From: Laura Gibbons <Laura.Gibbons@arun.gov.uk>
Sent: 16 February 2021 15:36
To: Planning.Responses <Planning.Responses@arun.gov.uk>
Cc: Simon Davis <Simon.Davis@arun.gov.uk>
Subject: RE: Planning Consultation on: Y/155/20/DOC

Application No: Y/155/20/DOC

Site Address: Land at Bilsham Road

Description of Works: Approval of details reserved by condition imposed under ref Y/91/17/OUT relating to Condition Nos 7 - landscaping & layout, 8 - Arboricultural Method Statement & Tree Protection Plan, 10 - surface water drainage, 13 - Ecological Management & Mitigation Plan, 15 - external lighting and 21 - Travel Plan.

BILSHAM ROAD, YAPTON			
Drawing Title: PRELIMINARY ENGINEERING LAYOUT. SHEET 2 OF 2			
Client: BILSHAM ROAD DEVELOPMENT LLP			
Scale: 1:500 @A0	Date: FEB 20	Designed: NA	
Drawn: LS	Checked: JH	Approved: GG	
Job No: 19-326	Drawing No: 19-326/010	Rev: J

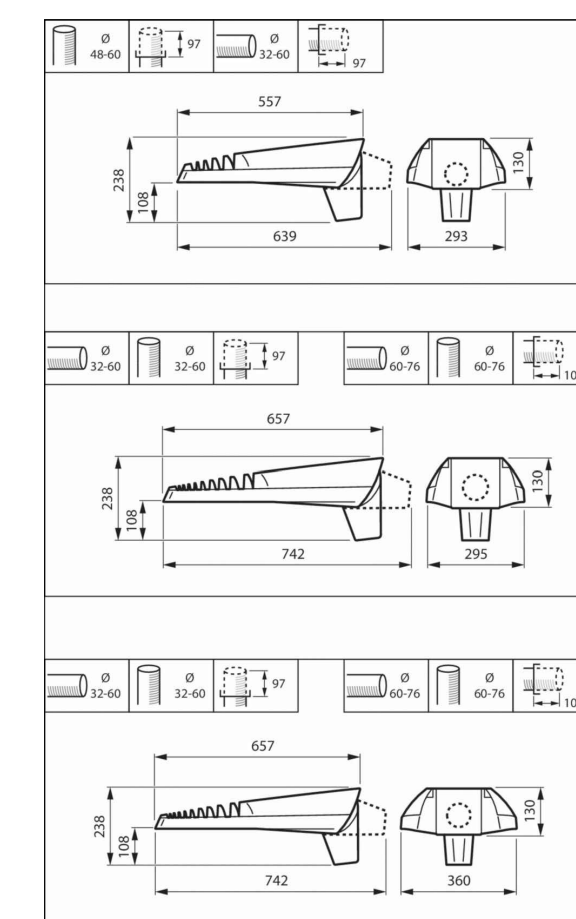
1. Infiltration testing was completed in February 2019. Only one test was completed in each location and tests were abandoned quickly. It can be observed that some test pits did show a decrease in water level over the monitoring period and the tests appear to have been terminated because of time constraints rather than evidence of water not falling. I note that in previous correspondence with the applicant it was agreed to ignore infiltration in site design. In the future it should be noted that a greater allowance of time should be given for infiltration testing.
2. Groundwater monitoring results must be provided and should be overlaid on detailed drainage layout drawings.
3. Detailed layout plans must be provided.
 - a. All pipes must be labelled with diameters and falls.

- b. Manhole invert and cover levels must be provided.
 - c. Catchpits must be clearly identified.
 - d. Finish and formation levels of permeable paving must be detailed on plan.

- e. Layout plans must show connections from roads, driveways and plots to the drainage network.
 - f. Hydrobrake unit references must be detailed on plans and construction detail drawings.

- g. The invert level of the proposed connections to the culvert and watercourse must be provided, along with the invert level of these existing features at the proposed points of connection. Upstream and downstream bed levels of watercourses must also be provided on plans.

9. A detailed review of calculations has not yet been undertaken due to the above. Please ensure that pipe reference numbers are included on layouts to facilitate review.

17. Note to be added to drawing to state that watercourses will be cleared of vegetation and silt as part of works. These works must be completed near the beginning of construction to ensure the free flow of water.
